Your Ref: OWPC5762
Our Ref: FP/85/15/HH
Please ask for:
Mrs J Chapman

19th May 2015

Two storey side extension
18 Outerwyke Gardens Felpham

Plans [As Proposed]

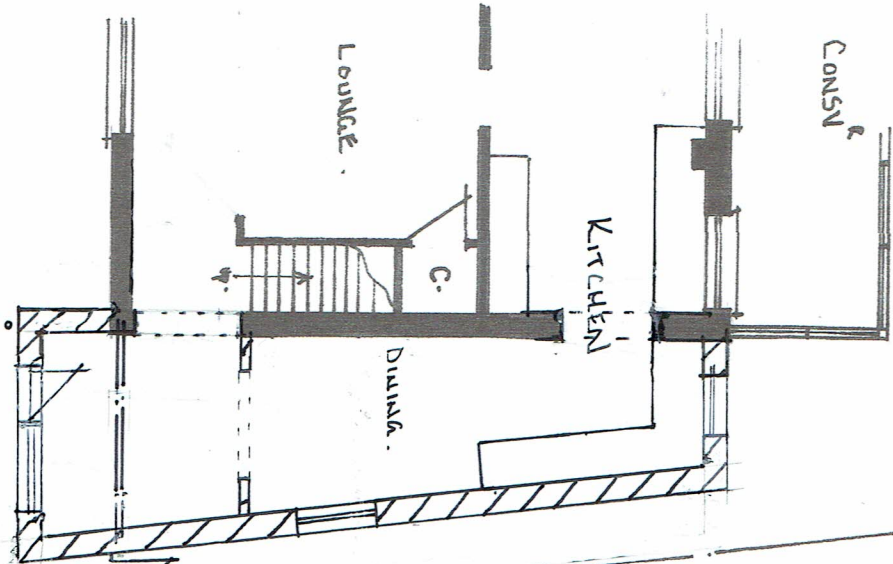
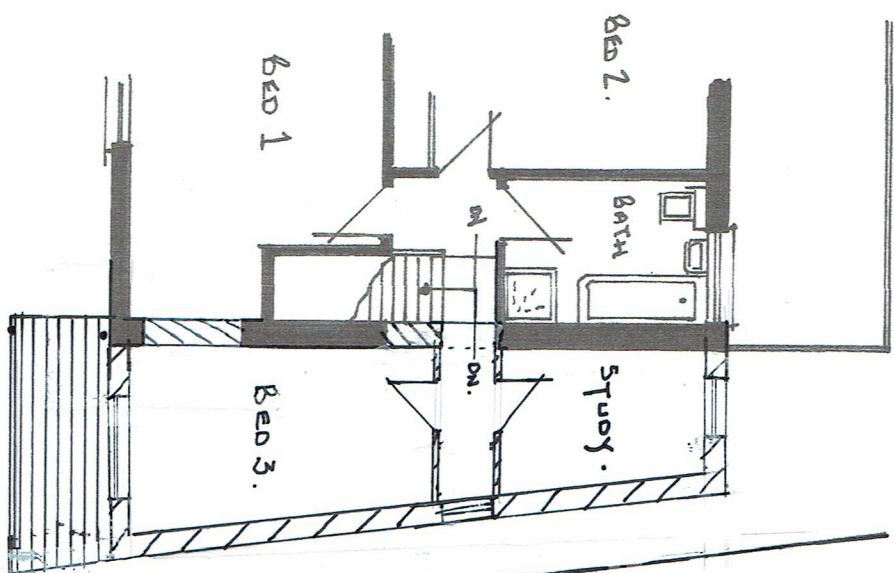
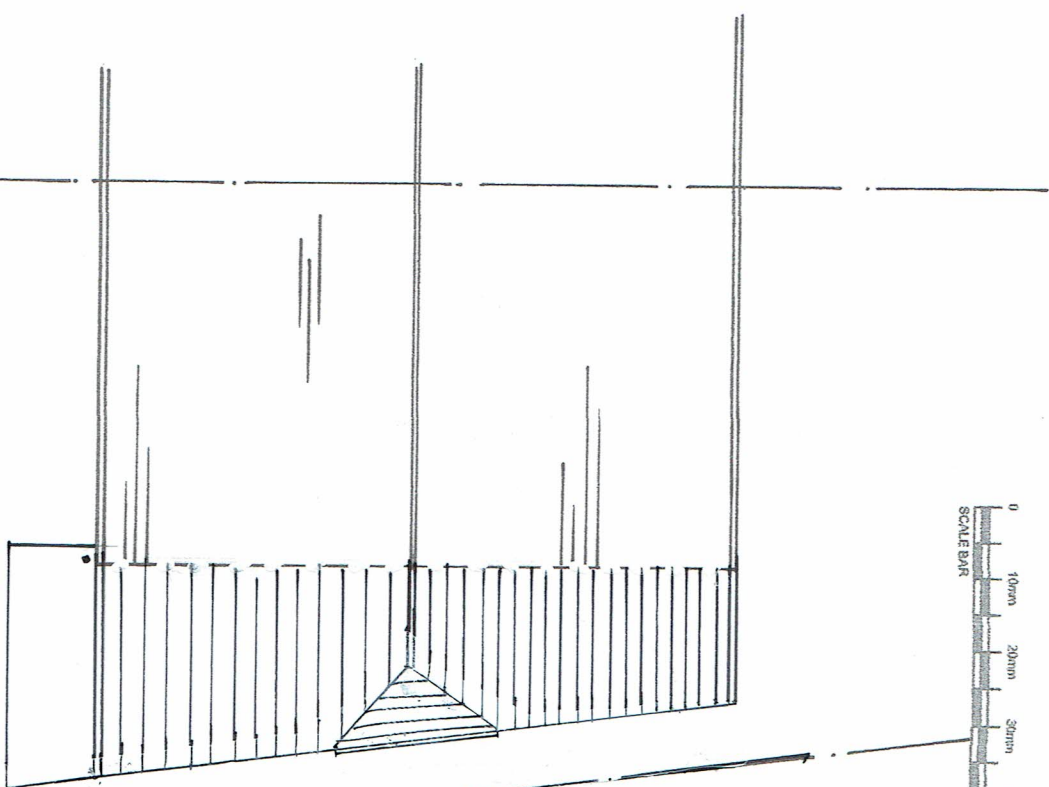
Objection - first floor should be 1 metre back from boundary - this application shows a gap of 0.8m at its widest point.
